From: David Easton
Sent: 20 December 2017 09:19
To: Karen Parsons
Subject: FW: A/155/17/OUT - Avenals Barn, Angmering
Attachments: Proposed dwellings - Plan Elevations.pdf; Proposed dwellings - Site plans.pdf

Subject: A/155/17/OUT - Avenais Barn, Angmering

PROPOSED SITE PLAN 1:200

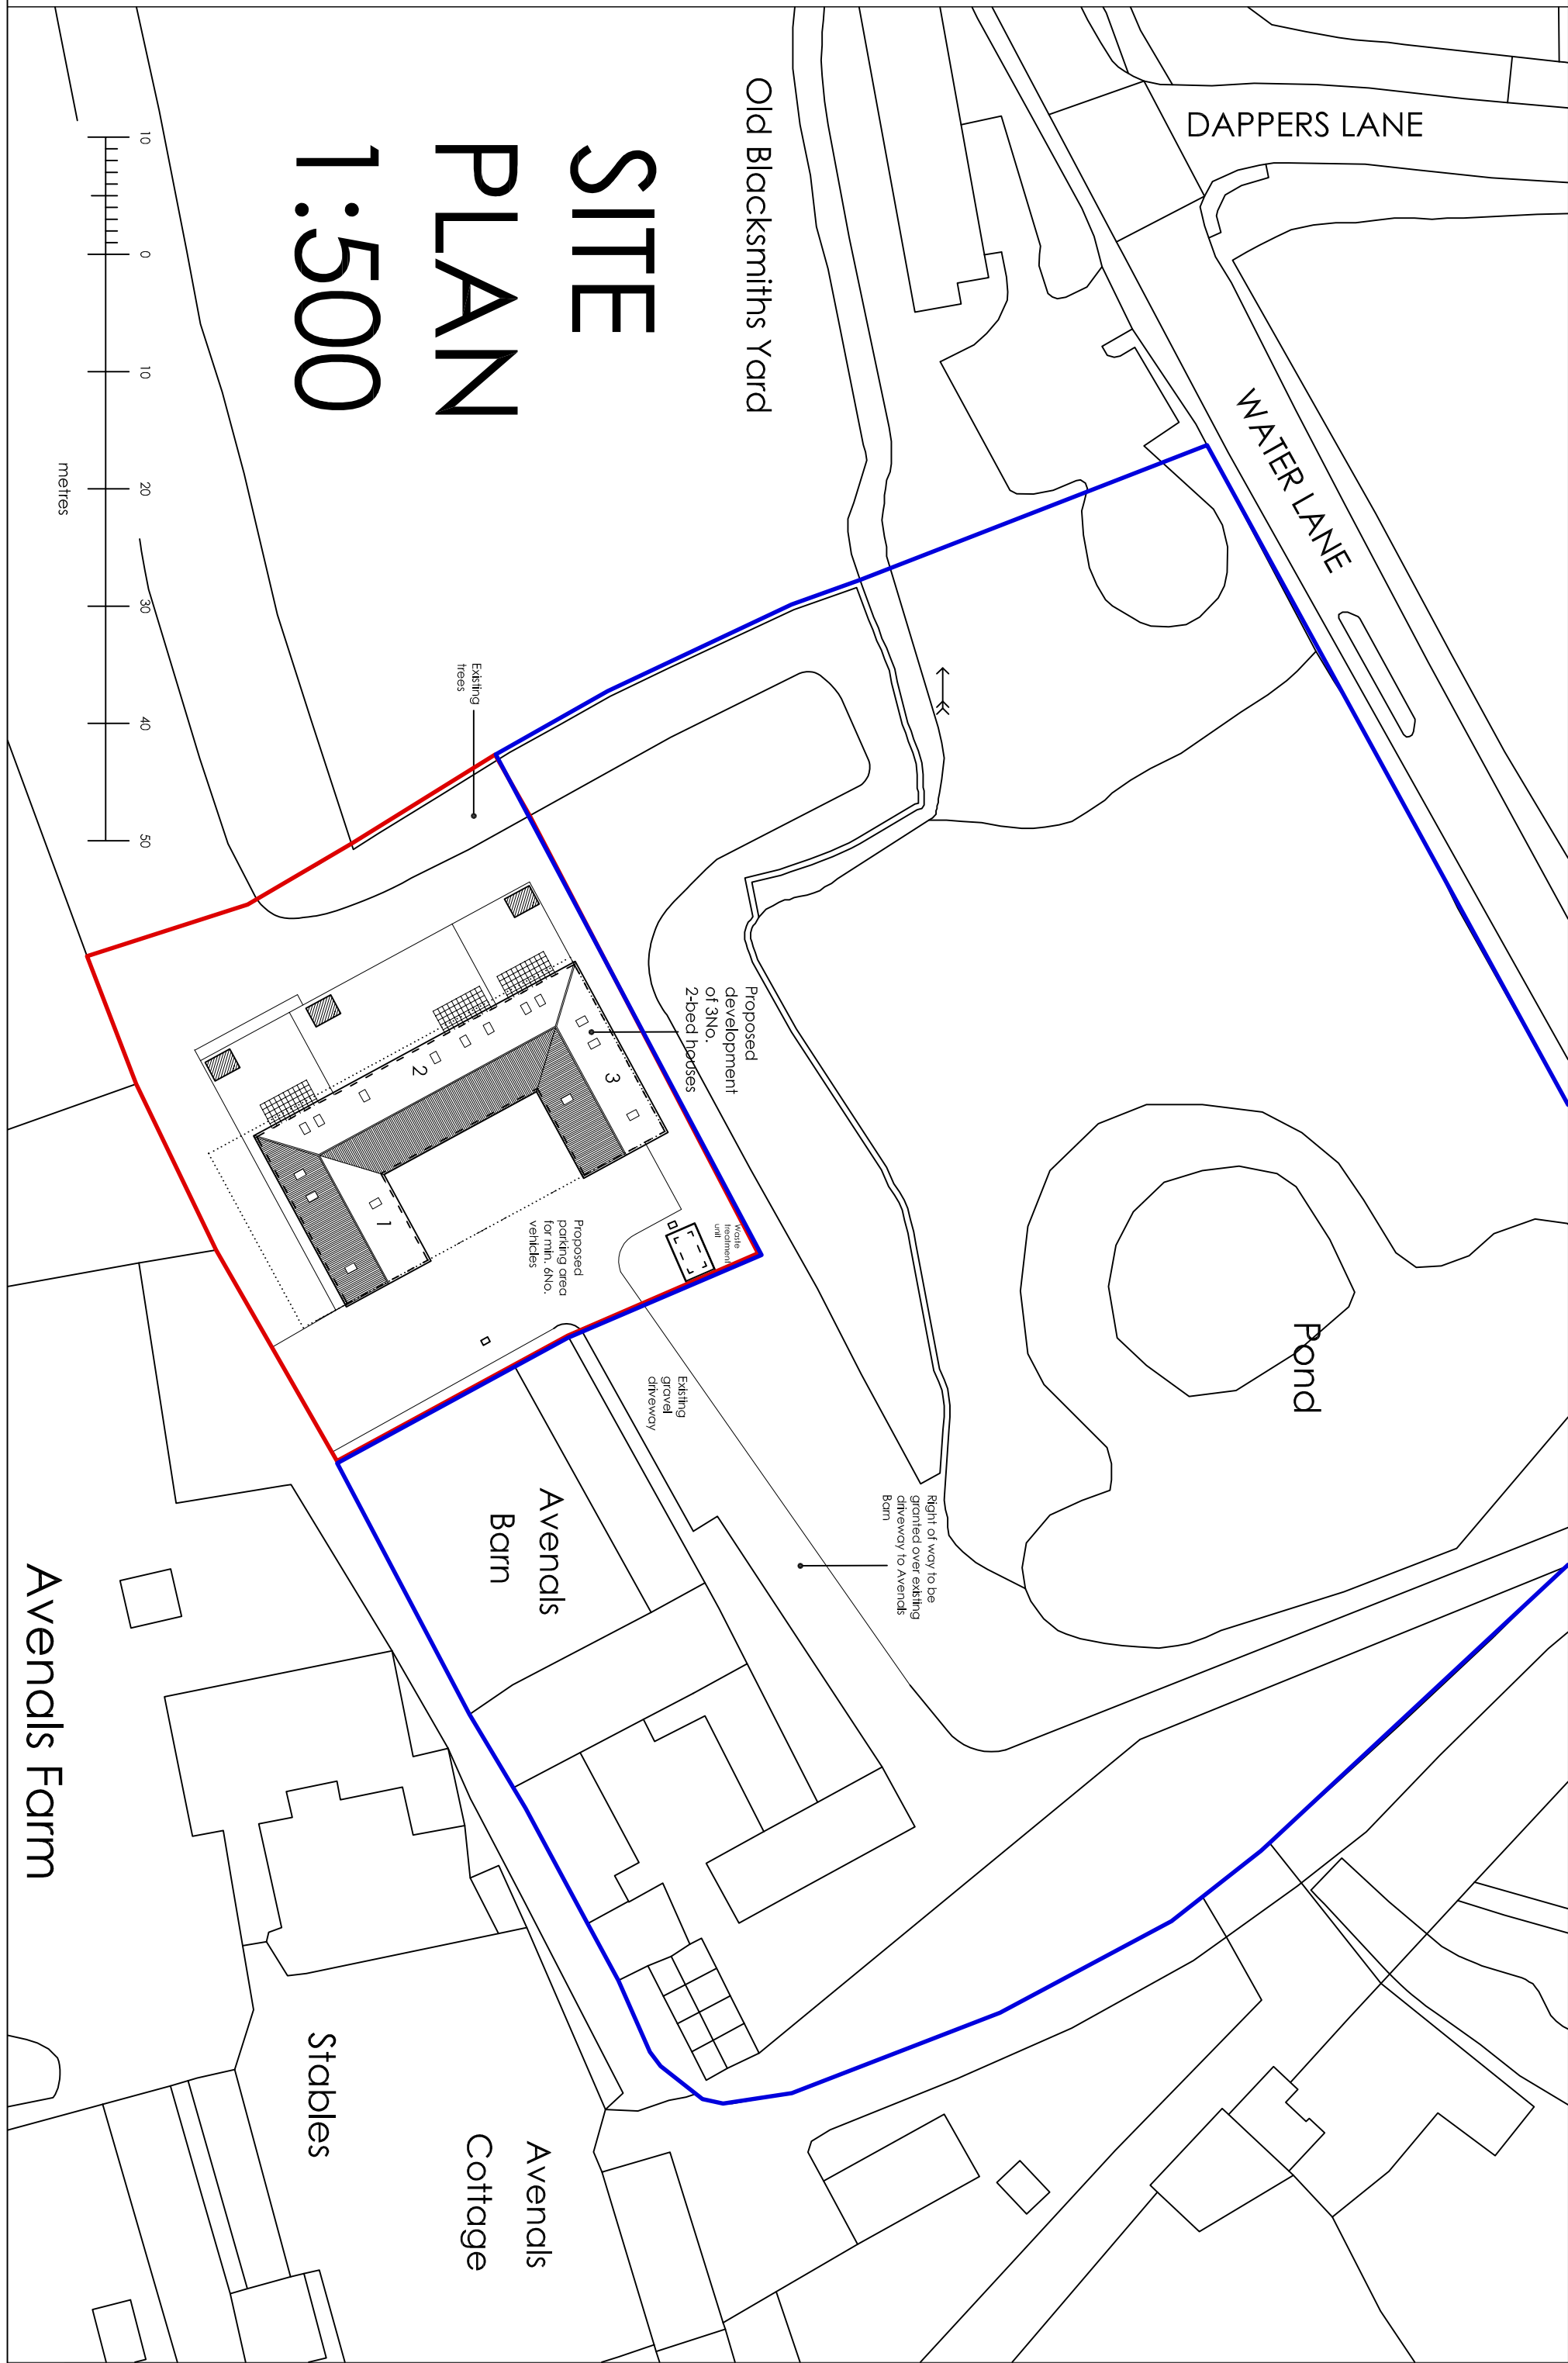
As discussed the major concern held by the Council at this time relates to the severance of the site due to the absence of a pedestrian footway along Water Lane. Therefore, despite the distances being considered acceptable the absence of this pedestrian link prevents the site from being considered sustainable. However, following our discussions you have advised that the applicant in this case owns the land to the west of the application site and as such the red edge could be extended to Weaver's Hill to provide a pedestrian link into Angmering. Therefore, I would advise that an location plan is submitted to allow the LPA to secure this pedestrian link.

I have also advised that some concerns exist in relation to the garden sizes of Plot 1 and 3 and as such recommend that some consideration is given to how best to meet the requirements of policy D DM3 of the emerging Local Plan.

1. The depth of the rear gardens have been increased to 10m
2. In order to provide sustainability, a footpath / cycle link has been included to Weavers Hill. Please note that the client owns this plot of land and therefore the blue line has been extended around the field.
3. The patio door to the front elevation has been removed and replaced with 2 windows. The patio doors will only be seen from the rear of the property.

Date: July 2017 Scales: As shown Paper size: A1 Dwg No: AR-122-02-A

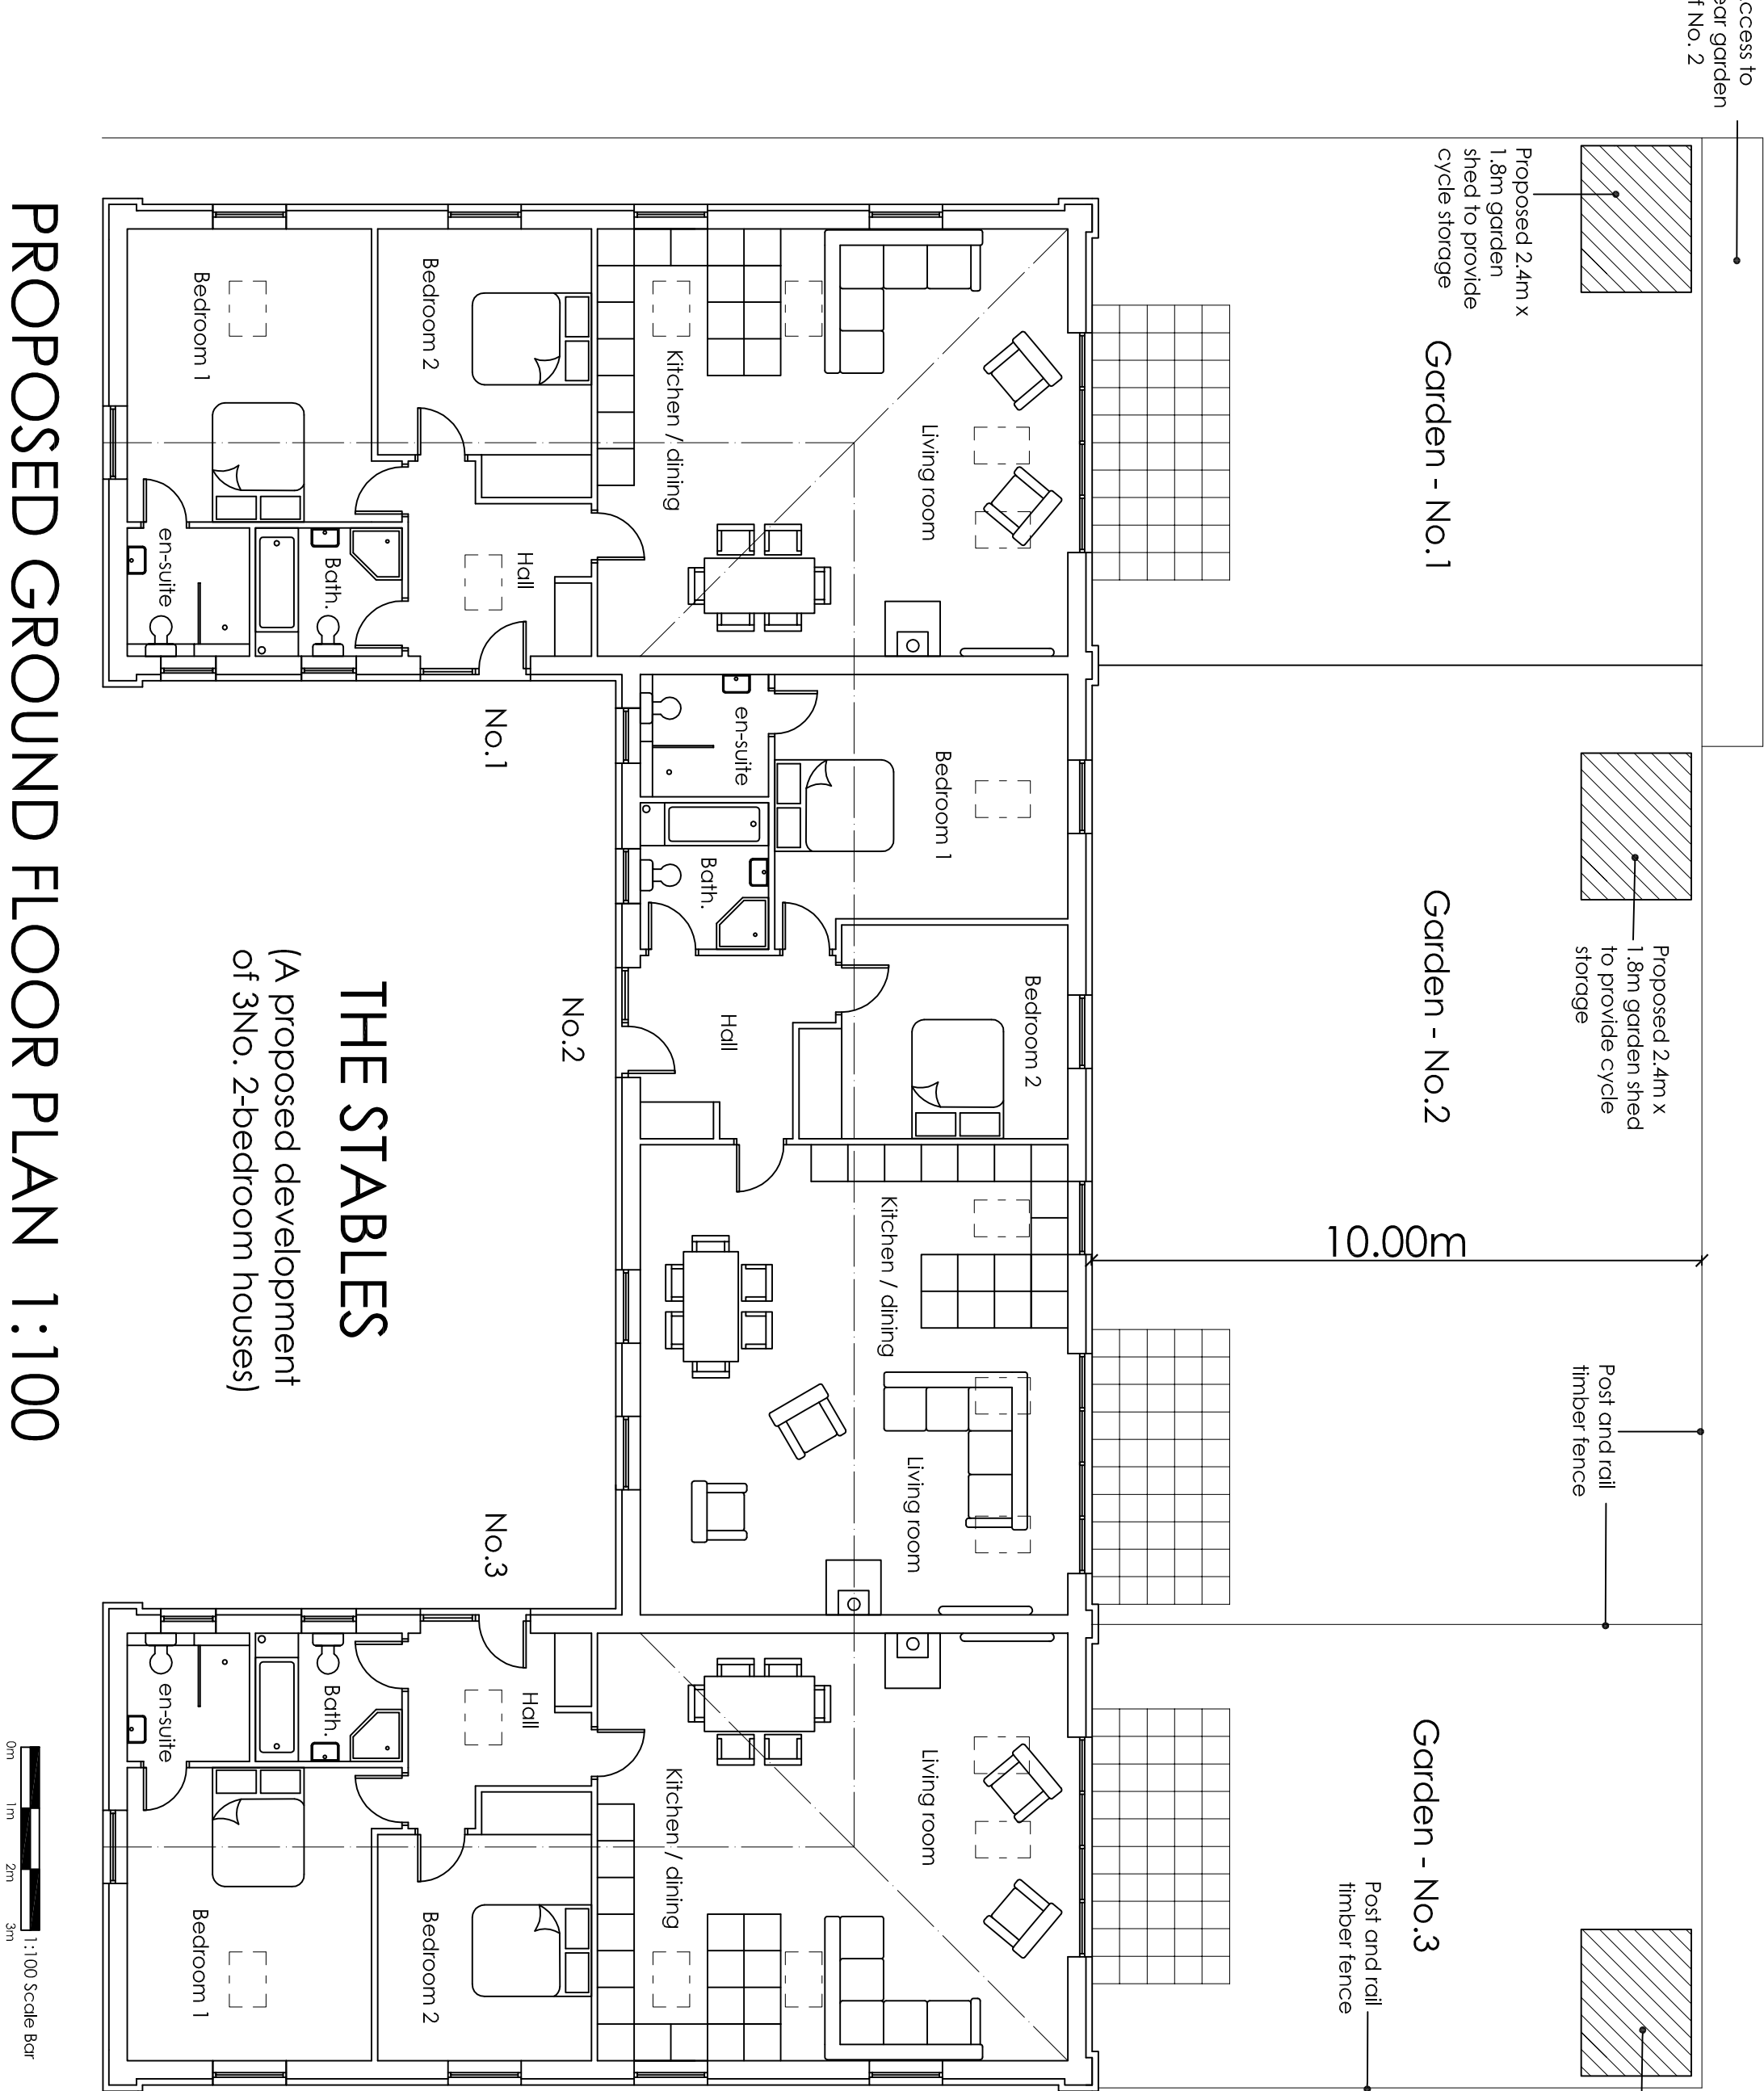
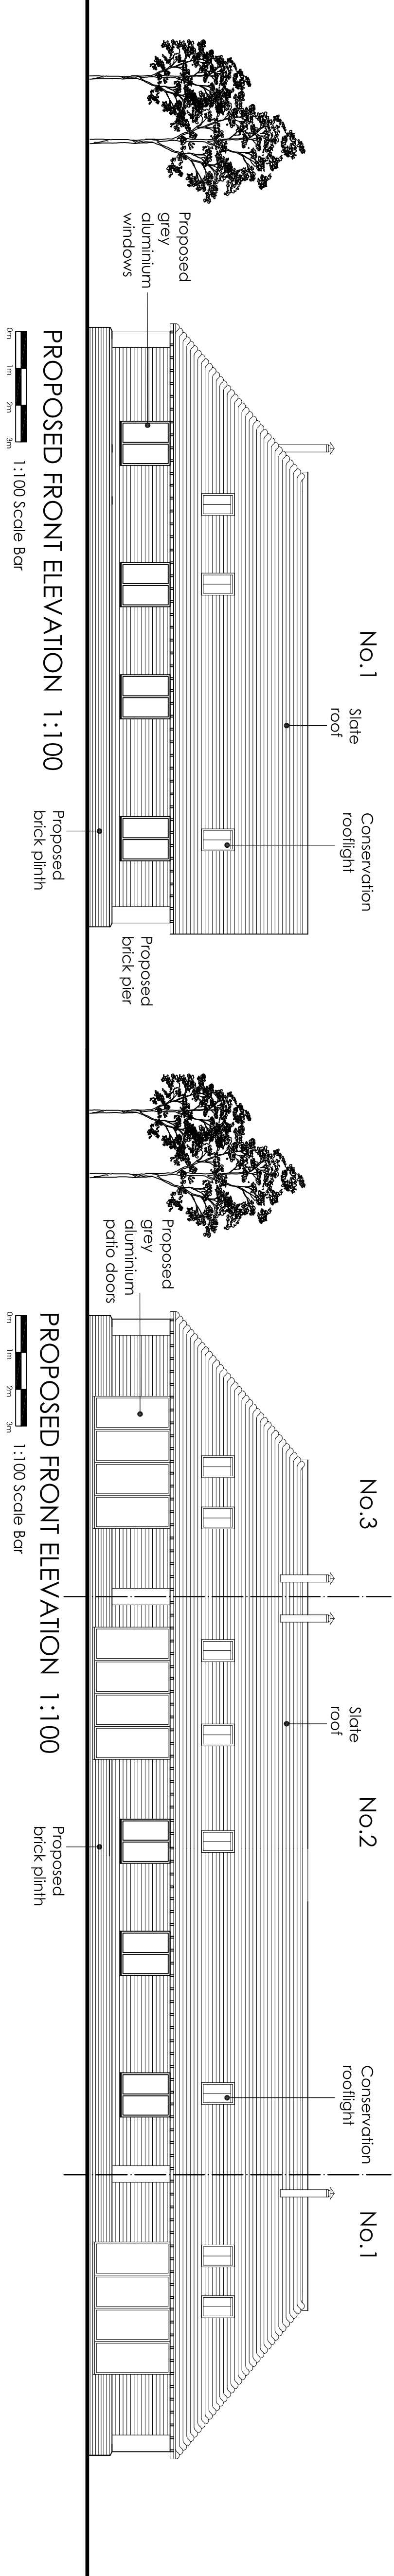
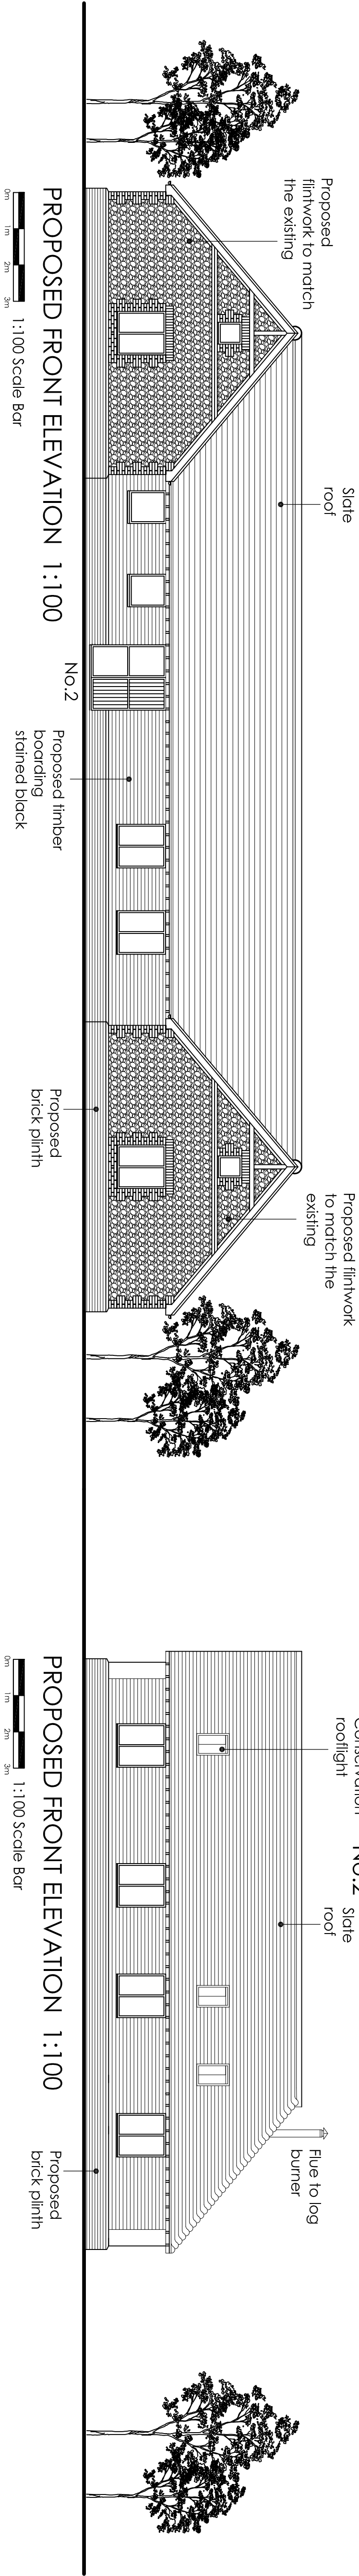
I am also aware of your concerns regarding the comments of the Council's Conservation Officer and I will try to discuss this with her when she is next in the office.
